Application No: EP/23/22/HH
Site Address: 5 Chiltern Close East Preston BN16 1RE
Description of works: Conversion of roofspace to habitable, including hip to gable enlargement and a rear dormer and front rooflight, single storey rear extension, and timber framed lean to porch to front.

Thank you for your internet representation made on 11th April 2022 which has been recorded as an objection with the comments as follows:

ELEVATION AND
SECTIONAL ELEVATION
AS PROPOSED

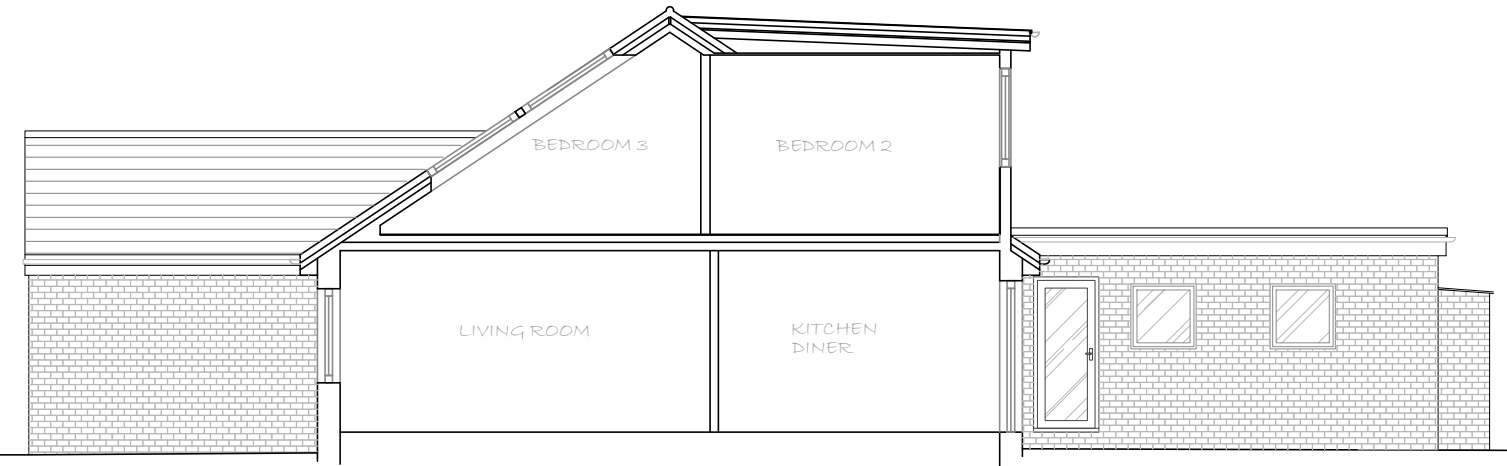
I write on behalf of the East Preston and Kingston Preservation Society. This application proposes significant additions to a small bungalow in a compact close of similar small bungalows. We do not object to the single storey rear extension, but the stark vertical hip to gable enlargement at the west side would have a negative impact on the street scene. A half- or barn hip, as on two or three bungalows in the immediate area, might possibly be more acceptable, though the unbalancing of the symmetry of this pair of bungalows is objectionable. The rear dormer is also overly dominant and out of proportion to the original building. Is the garage to be converted to residential use? The porch proposed would make it difficult or impossible to access for a car.
